## **Planning Inspectorate review of Early Adopter Programme products associated with Byers Gill Solar**

On 11 January 2024 the Applicant submitted the following documents for review:

- A draft DAD; and
- a draft PCD.

Drawing Title  
**ES Figure 2.10  
Typical transformer, inverter and  
BESS arrangement**

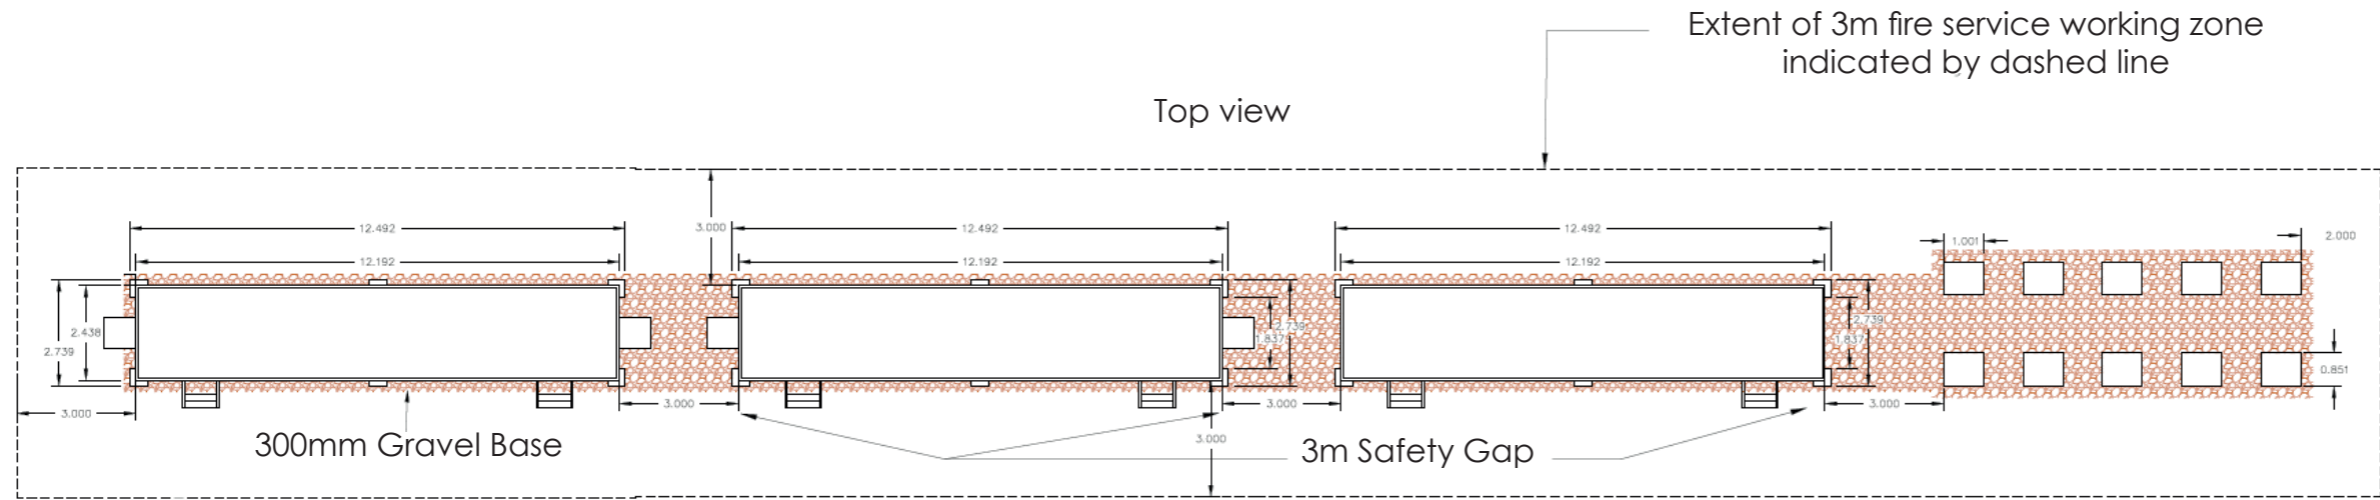
- Section 7 outlines the dimensions, materials and engineering of the project; including the significant number of containers to be distributed across the site to house key equipment including BESS, inverters and transformers. The emphasis is on how these containers might be 'hidden' from the view of receptors; however, it would be helpful to address a positive approach to design and explain what range of materials and colour palette might be adopted for these significant objects, including security fencing, that will sit in the landscape and inevitably (and correctly) be in view of users of nearby footpaths and highways and how they accord with the project's design principles.
